The Old Post Office  
Main St.  
Sibford Gower  
Banbury  
Oxon  
OX15 5RT

8 June 2015

**Re: 15/00810/F Stone Walls Bonds End Lane**

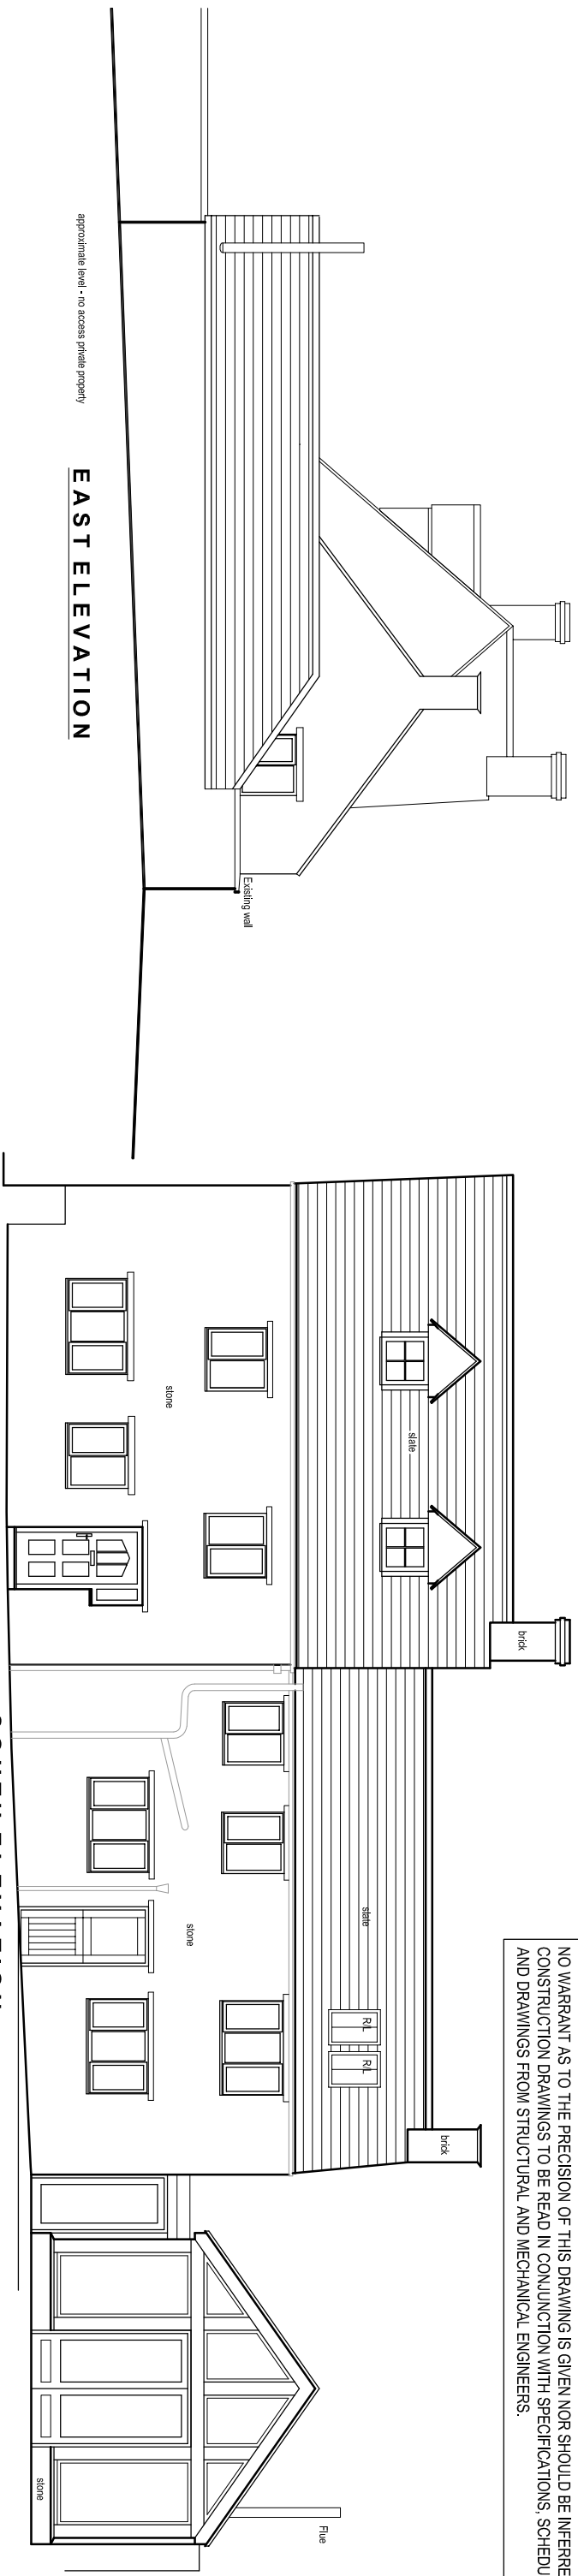
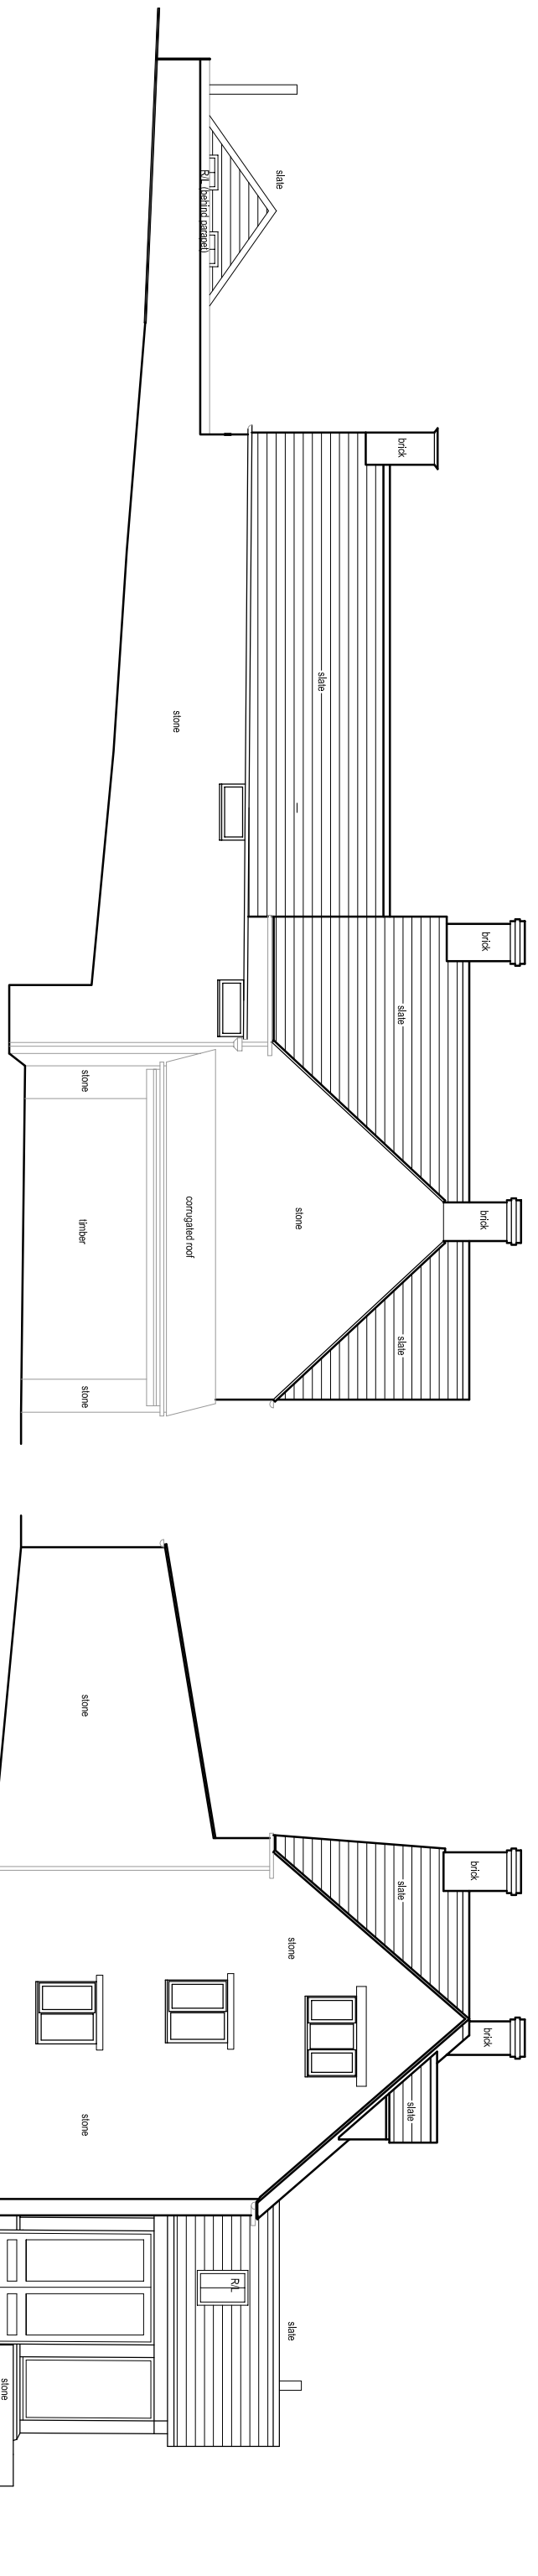
The other concern we have is the intention to install a wood burning stove to the east of the development this is next to the hedge and the flue of will be under the height of the hedge we believe that this is a fire hazard due to the nature of holly, we also believe the heat from the flue would be detrimental to the future health of the hedge. We would ask that the wood burner and flue be positioned so that the outlet is on the western side of the development to maximise the distance between it and the hedge.

CLIENT	Mr M Snales	SCALE	1:100 @ A3	DATE	December 2014
PROJECT	Stonewells, Bond End Lane, Sibford Gower, OX15 5RT	DRAWN	MH	CHECKED	MH
DRAWING TITLE	Ground Floor Plan	JOB NUMBER	1306	DRAWING NO.	12
	As Proposed Option 3			REVISION	B

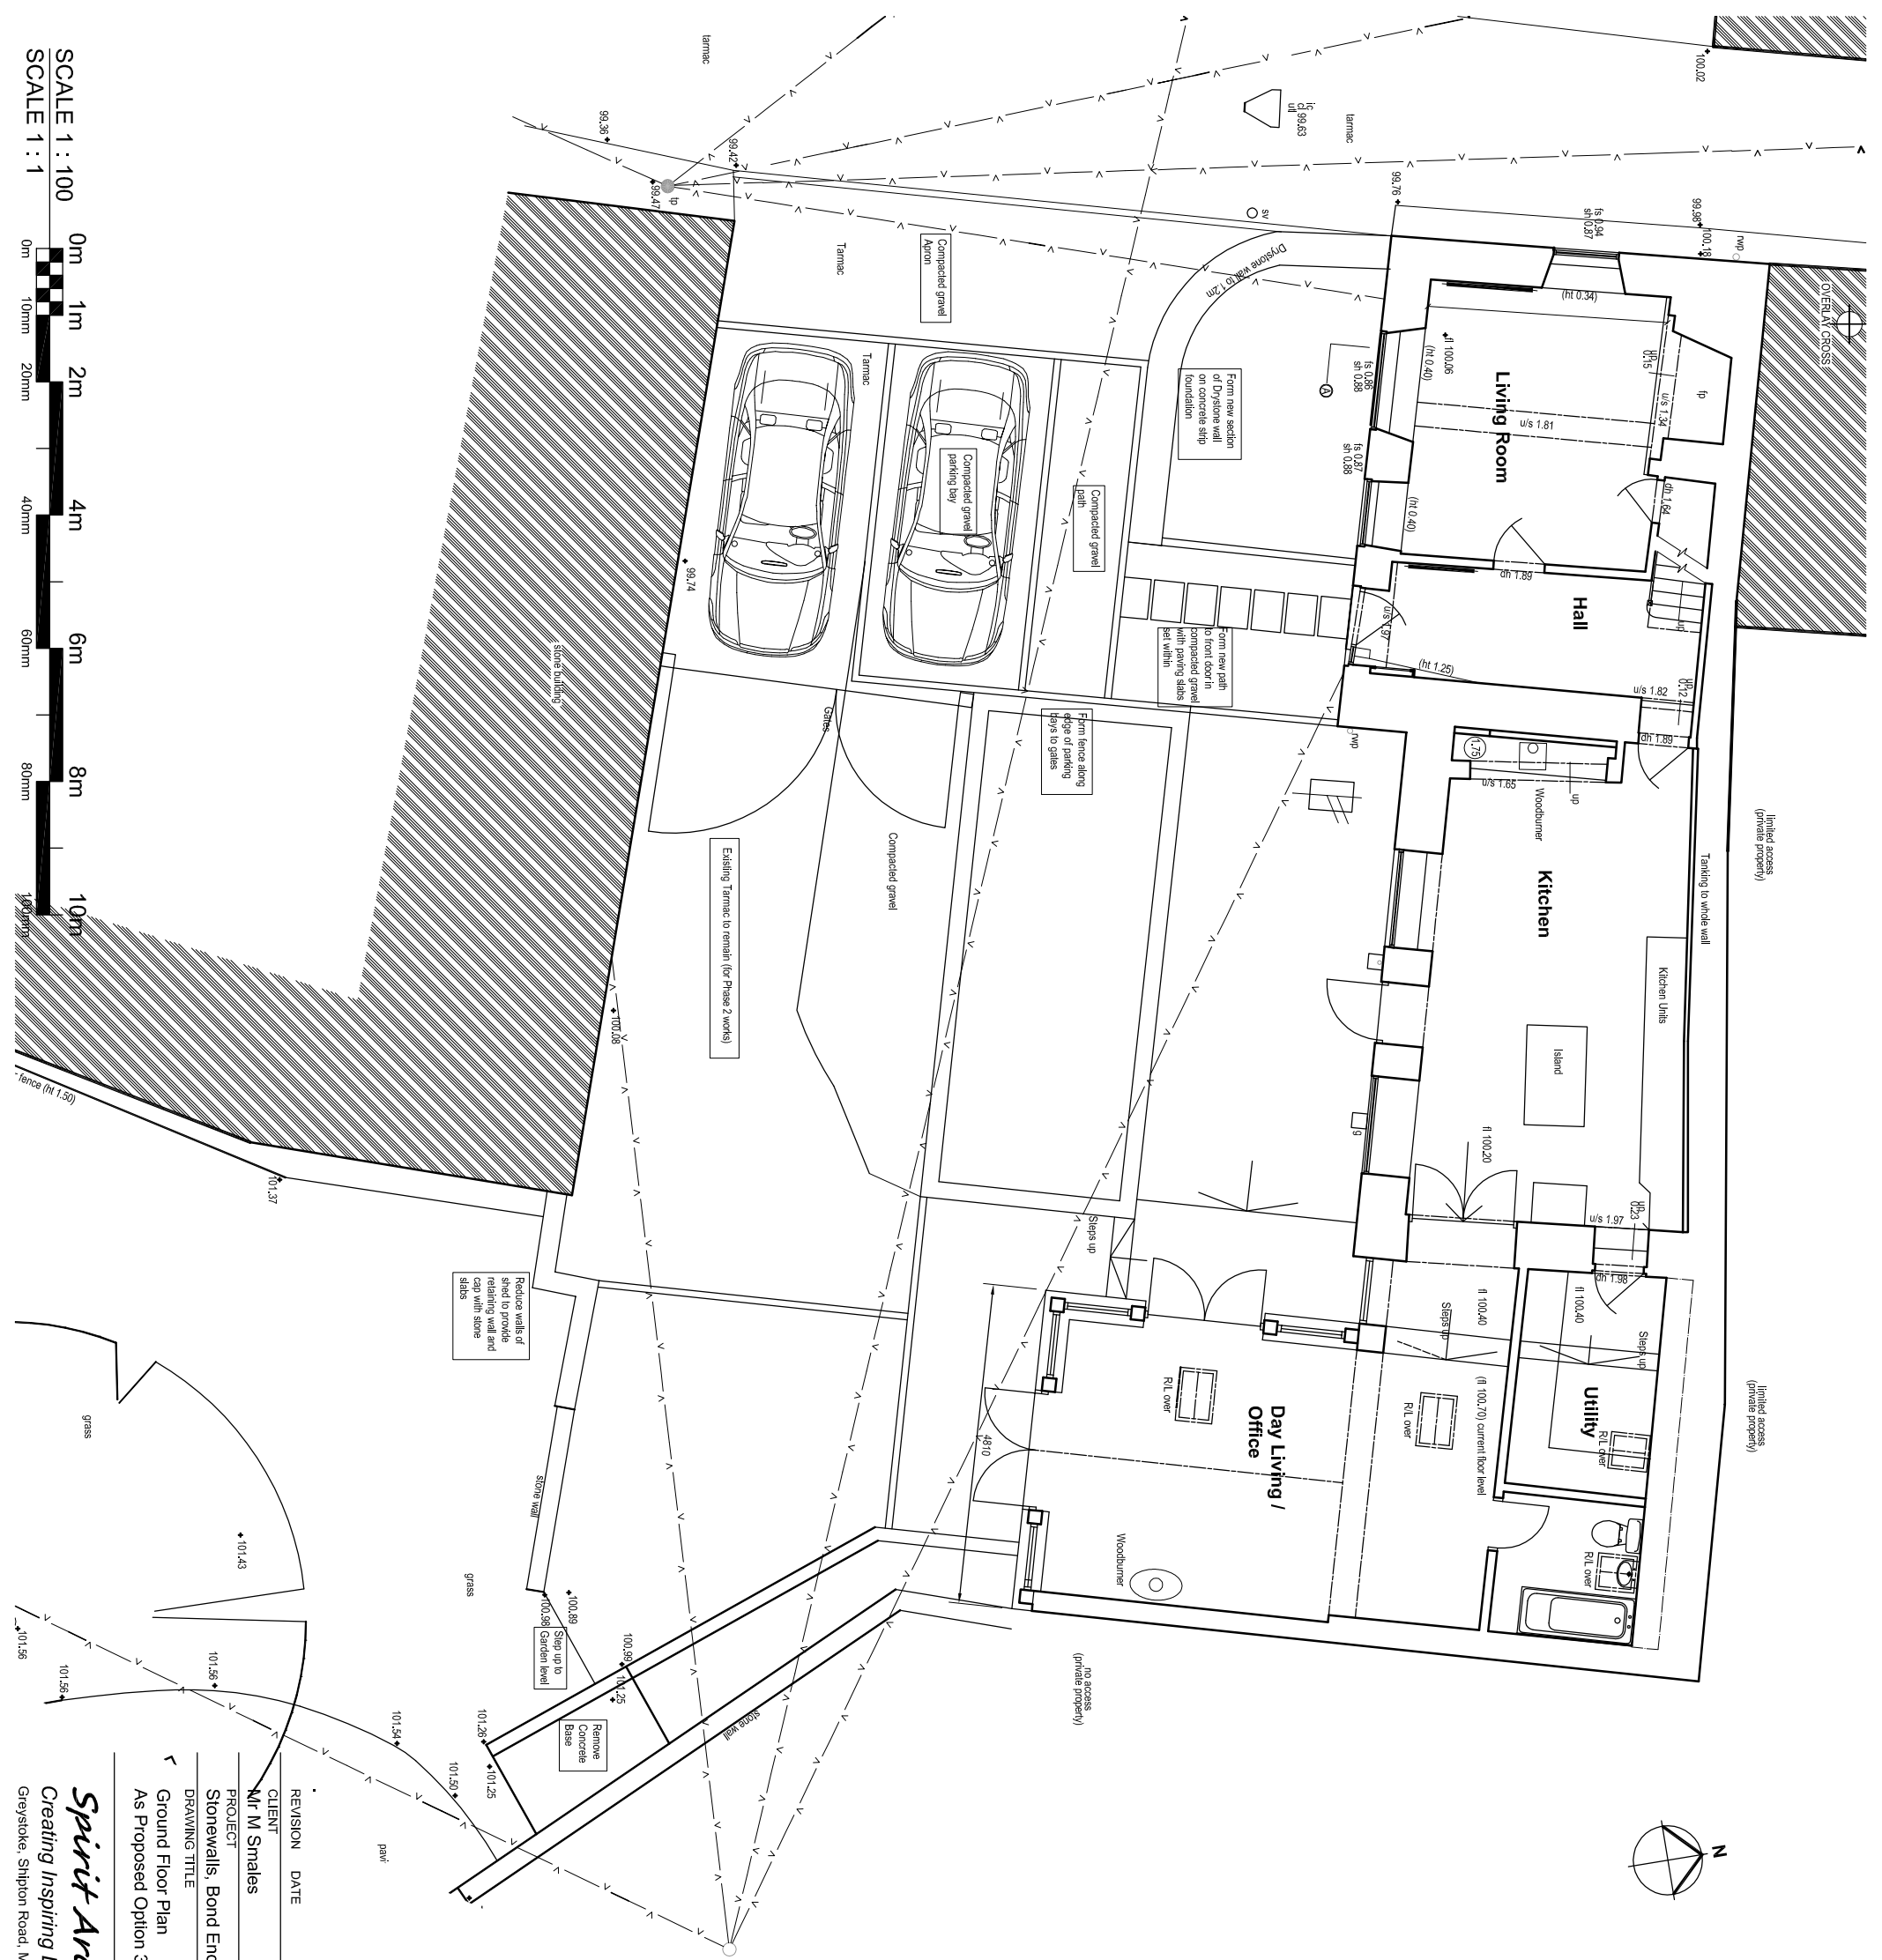
Because of this hedge and the higher ground level of our garden this means that the development will not be seen from our land and therefore has no visual impact, consequently we have no objections on these grounds. However we do have concerns about the impact of any development on the stability of the retaining wall we feel that the wall should be left intact as much as possible and not weakened or undermined in any way, as a result of this development.
